**wilbar associates ltd**  
HIGHWAY CONSULTANTS

**Transport and Highways Review**  
**Application No: P/58/19/PL**  
**Rear of Inglenook Hotel 253-255 Pagham Road**  
**Pagham PO21 3QB - Erection of 9 No. dwellings with**  
**associated access, parking, cycle & refuse storage**  
**& landscape design**

2017-3763-002

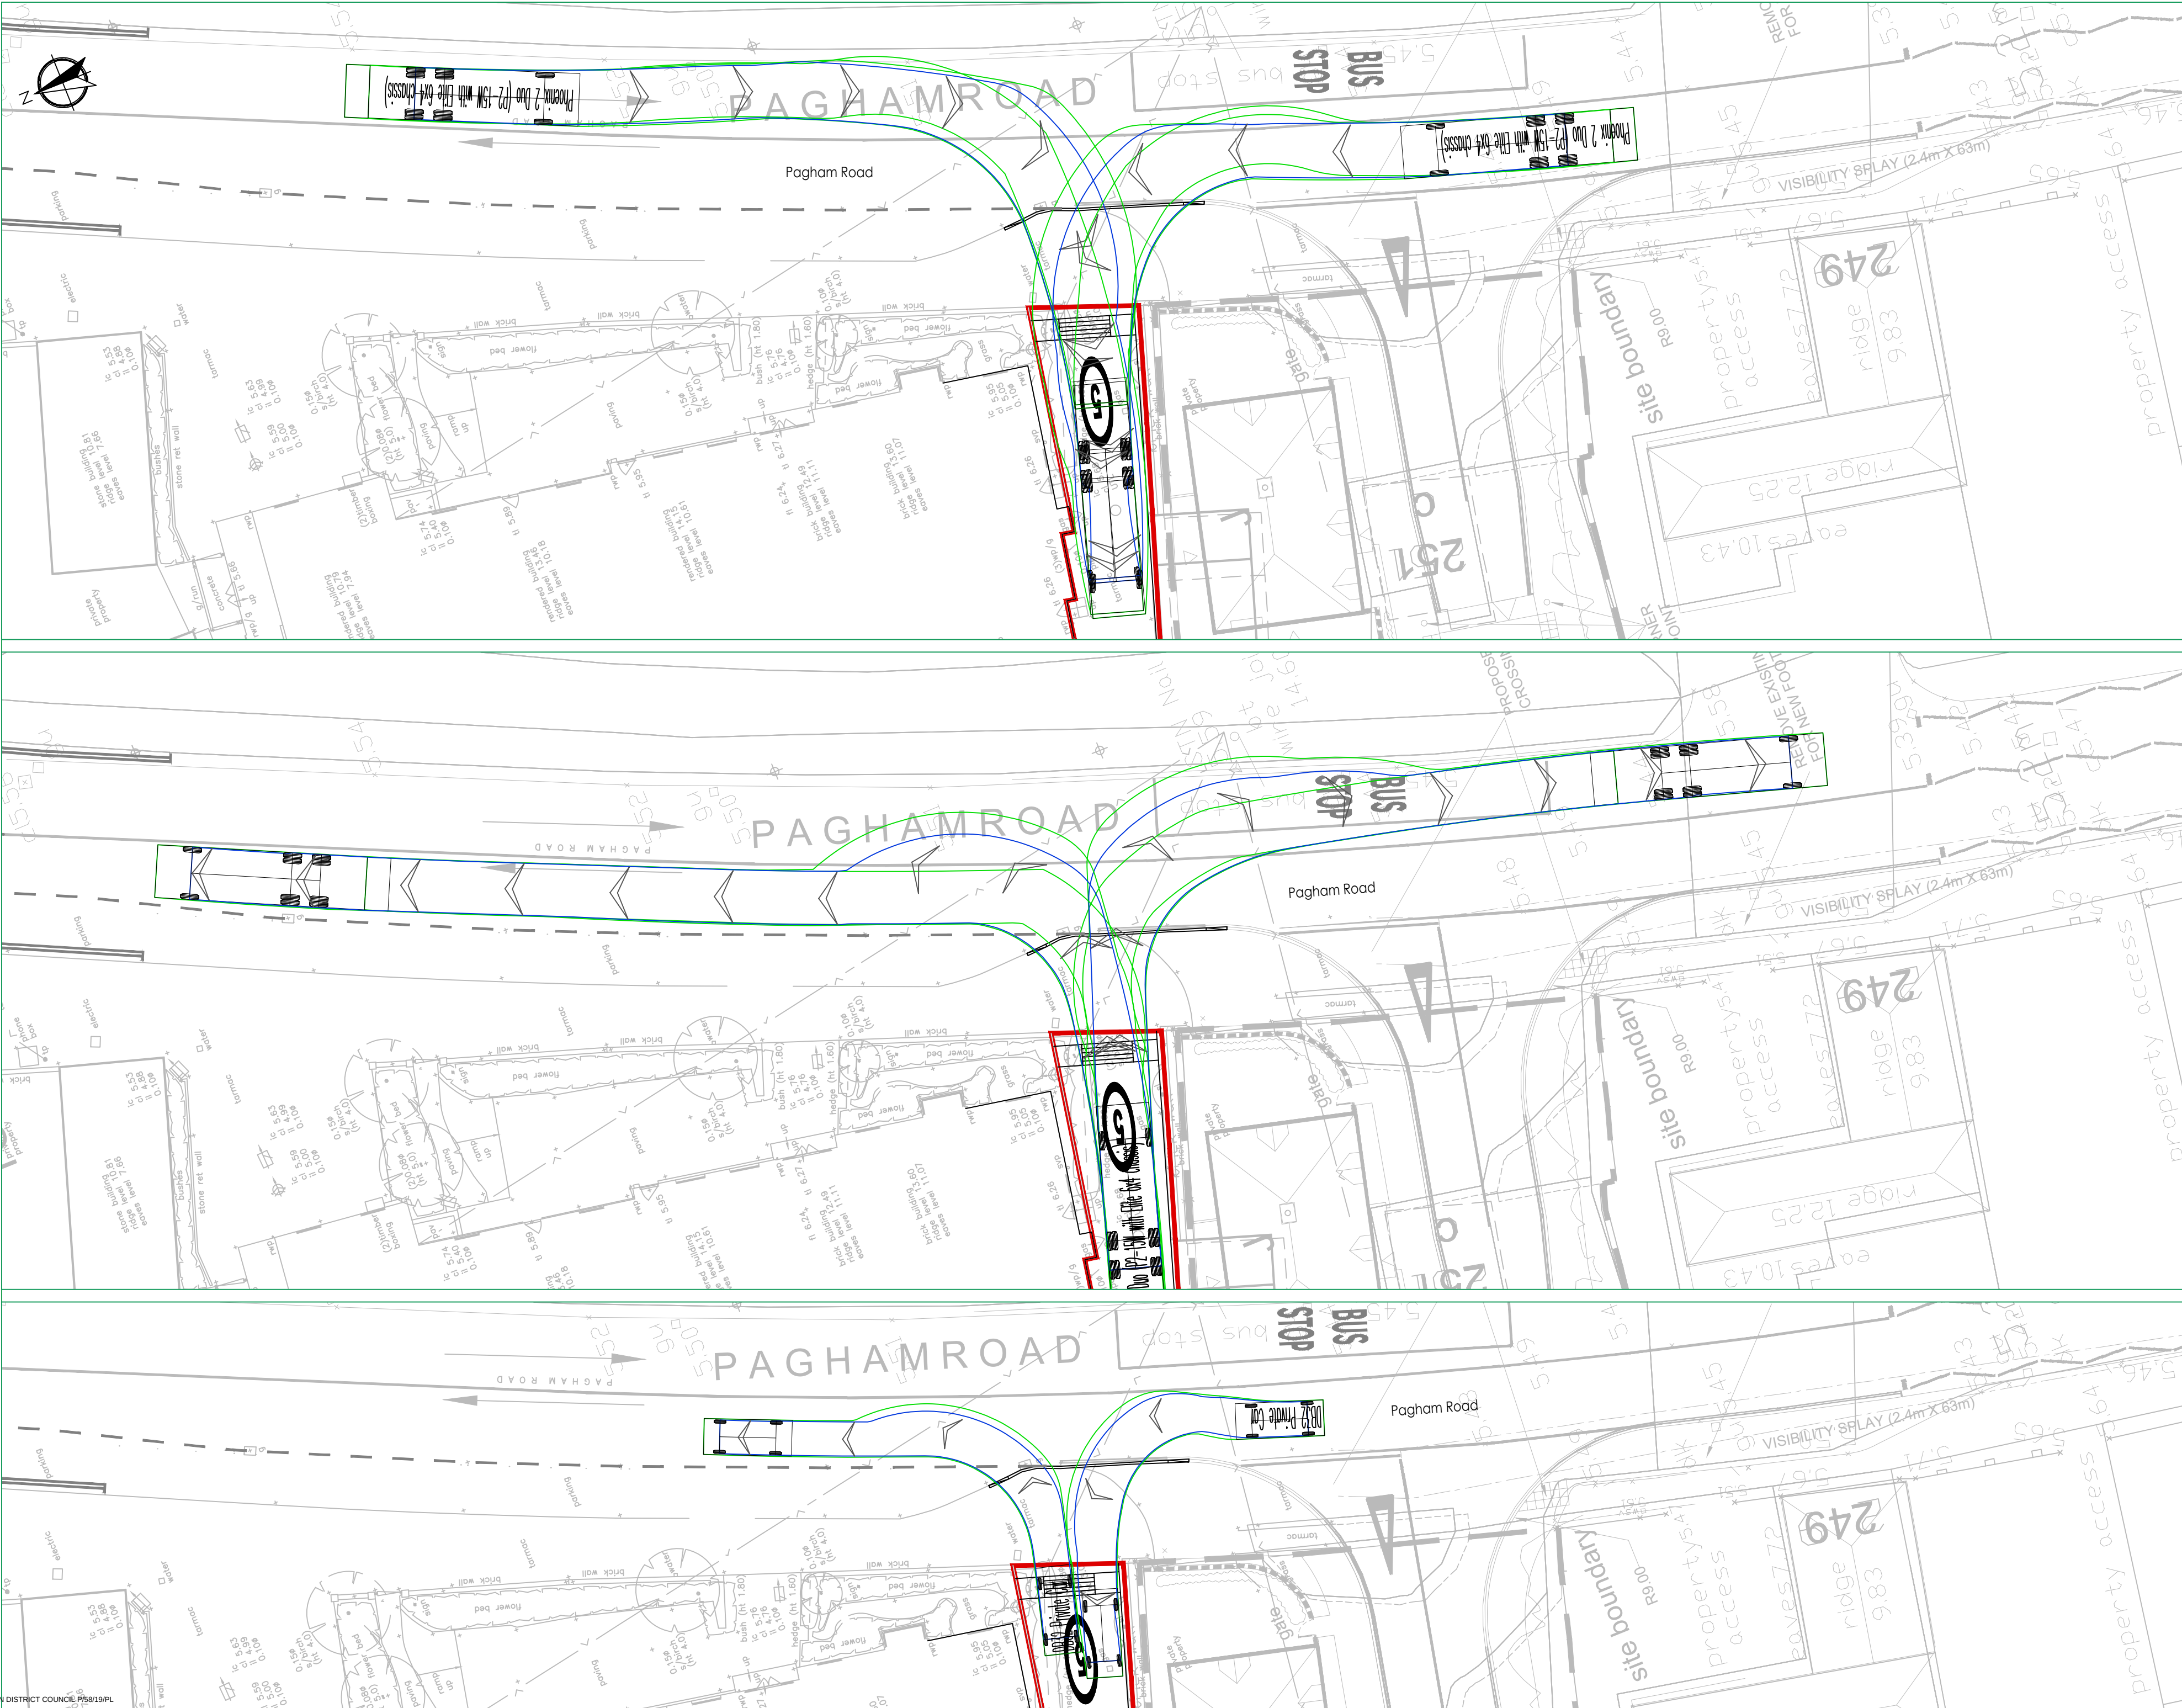
- 5.1.1 The proposed revised access layout is shown on Figure 5.1 below and includes some widening to the existing access to the engineers specification. A more detailed plan although superseded is provided in the Transport Statement Drg. No. 2017-3763-002 Rev A. This shows that the existing access is to be widened to 5.1 metres to allow for a refuse vehicle to exit and turn into Pagham Road although the text in the Transport Statement refers to widening from 3.5 metres to 5.3 metres. This results in the loss of a hedge and demolition of part of the boundary wall and widening of the existing vehicle crossover as shown on the plan. A swept path movement was shown on Drg. No. 2017-3763-003 Rev A included in the Transport Statement. The swept path doesn't take account of any parked vehicles on Pagham Road, there are currently no restrictions, a refuse vehicle would not be able to make a turn with the present arrangements without parking restrictions reducing the existing availability for residents and visitors on-street.

- 5.1.2 Visibility splays are shown for 30 mph with x dimension of 2.4m and y dimension of 43m. The visibility distance should be measured based on the stopping sight distance (SSD) of the 85<sup>th</sup> percentile speed as set out in Manual for Streets table 7.1 as extracted on Figure 5.2 below. From the recent speed surveys the 85<sup>th</sup> percentile speed is 30.4 mph (48.9 kph) and a SSD of 43 metres would compare to MfS. However Figure 5.3 and 5.4 show the visibility splay looking north and south from the access on Pagham Road that shows that the immediate visibility splay is blocked by parked vehicles to the north and the occasionally from the newly created access to the development to the south. MfS does suggest that occasional parking in visibility splays is quite common but defined bays should be provided outside visibility splays. The presence of the layby to the north will have a significant impact to the safety with the additional flow expected from the development at peak times.

This is shown on Figure 5.1. This is better provision than previous however this is not overlooked and may be vulnerable by users at night who will not feel secure. Further details will be required to review.
